WALDEN PRESERVE 2

Filing No. 4

Construction Drawings

PCD FILE NO. SF-18-034

OVERALL SITE PLAN

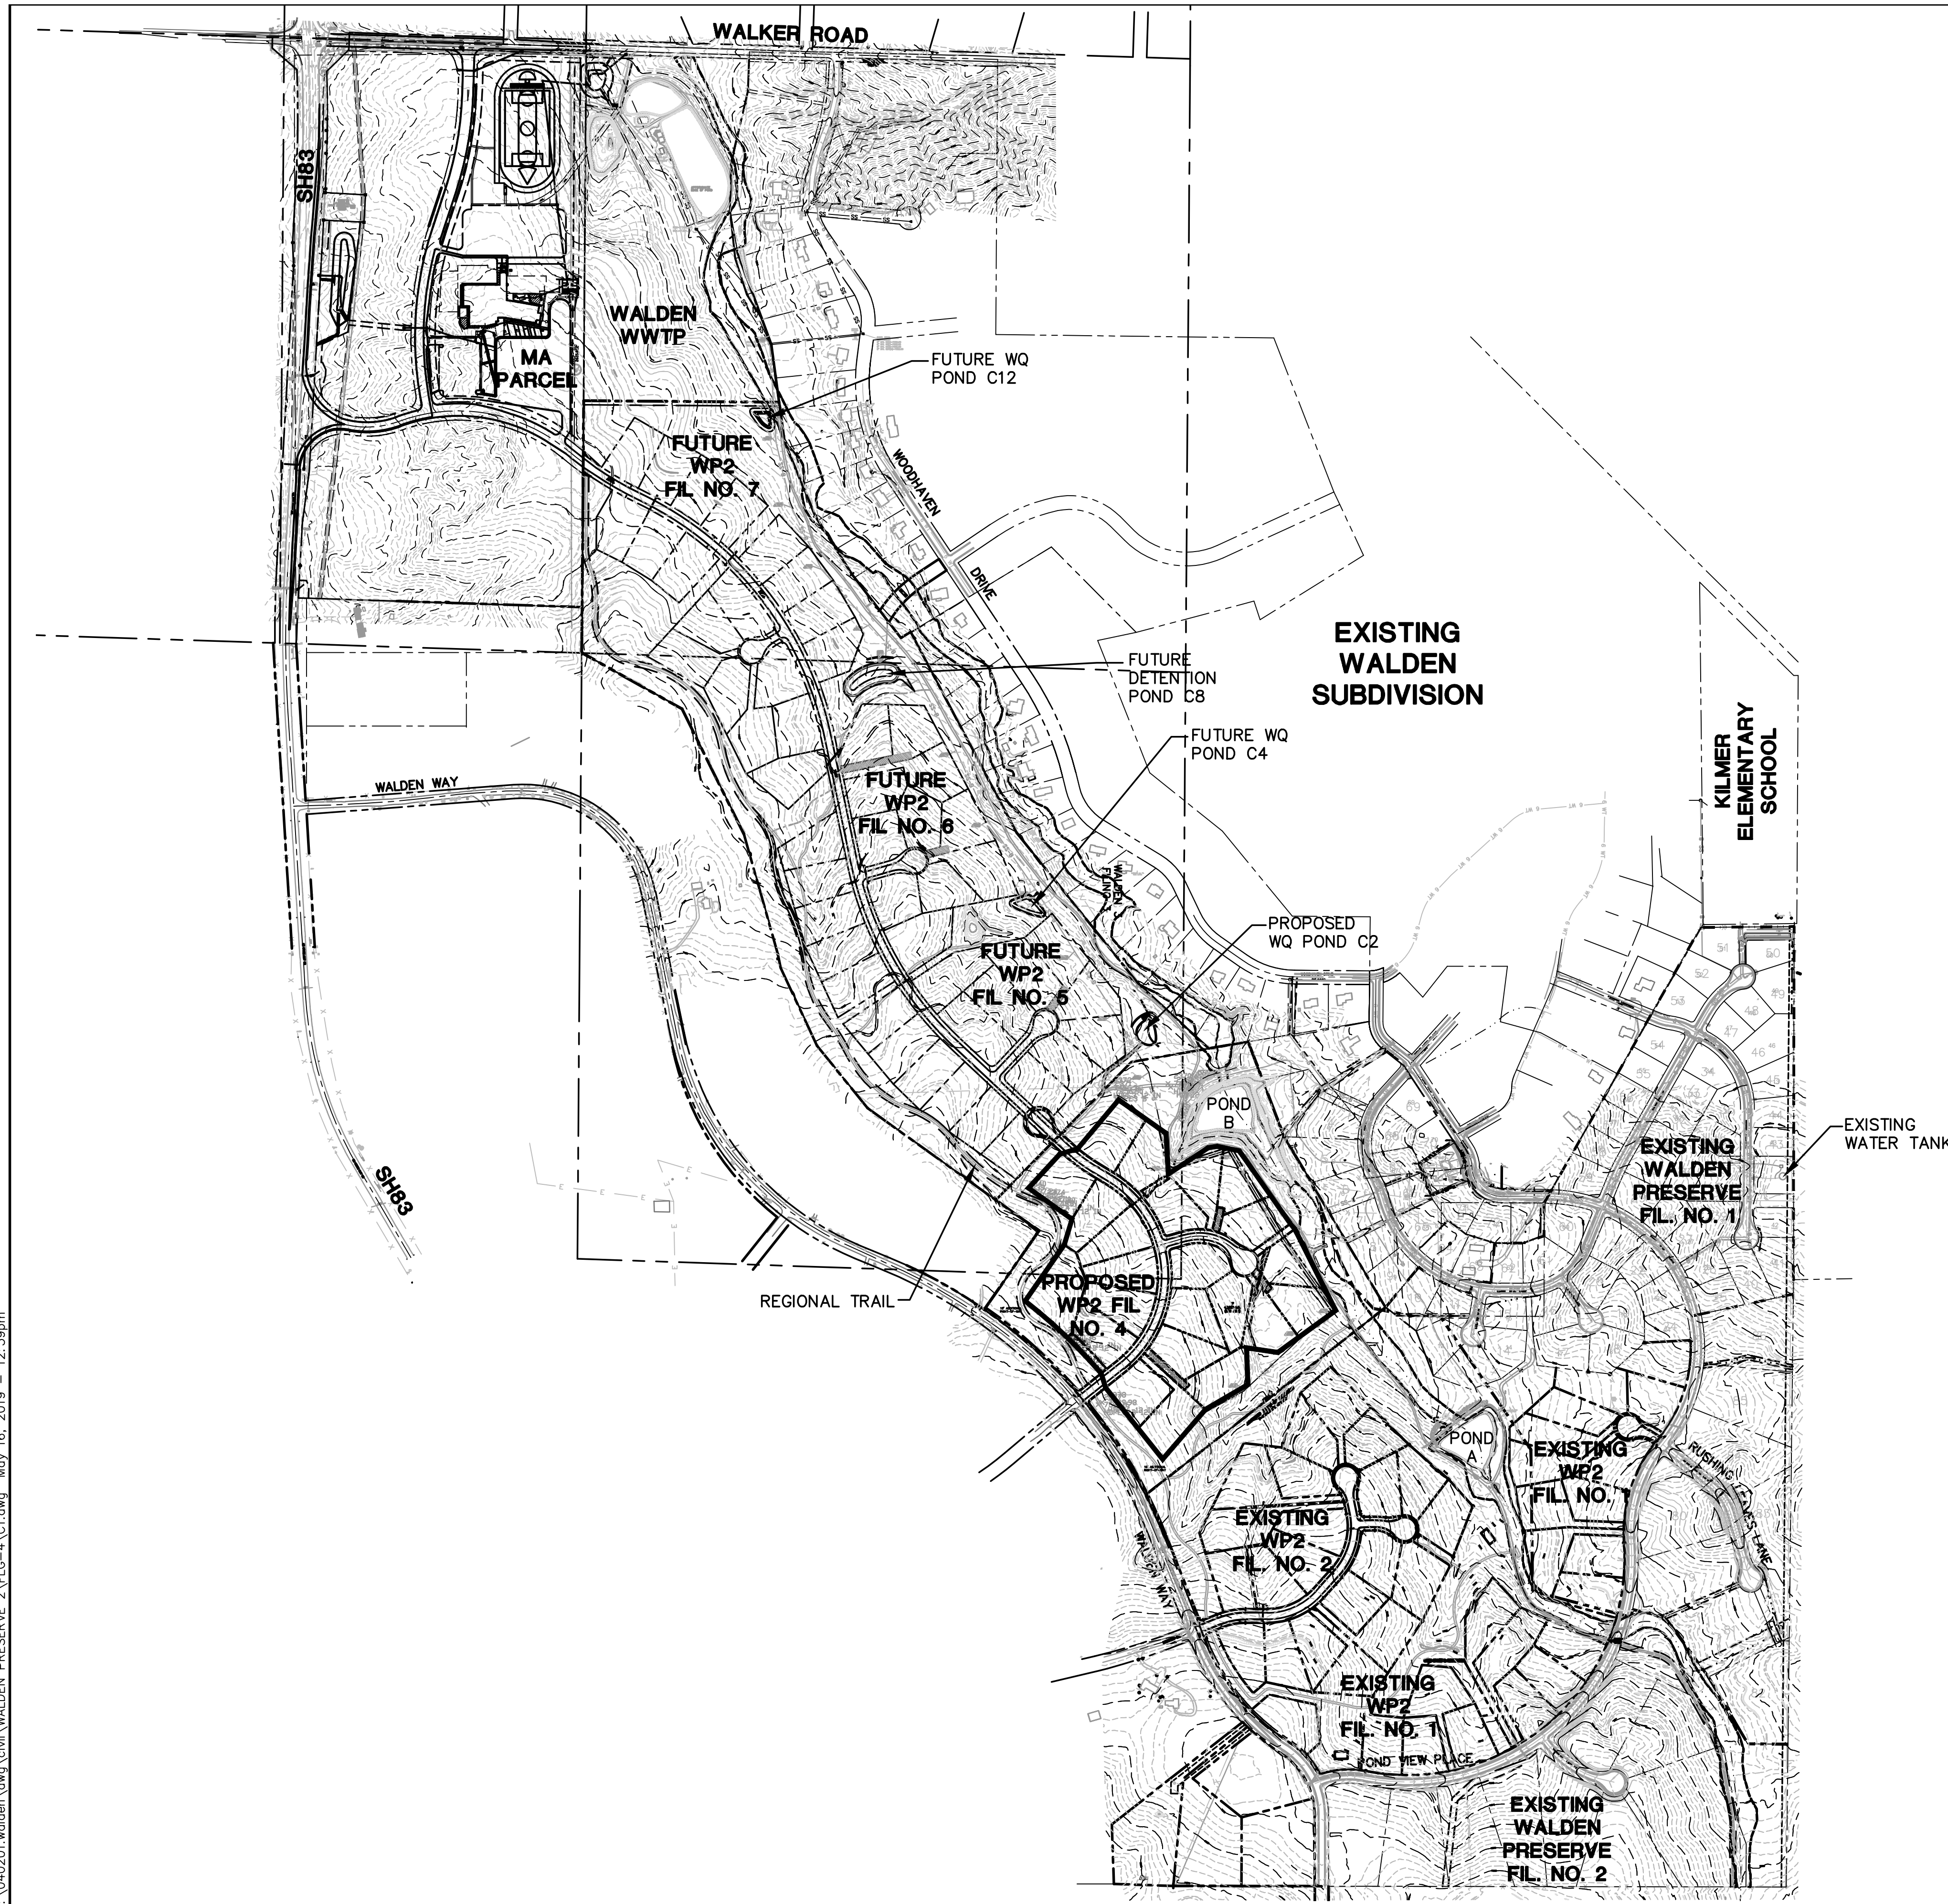
Update. Discrepancy with the FDR Driveway Culvert Summary
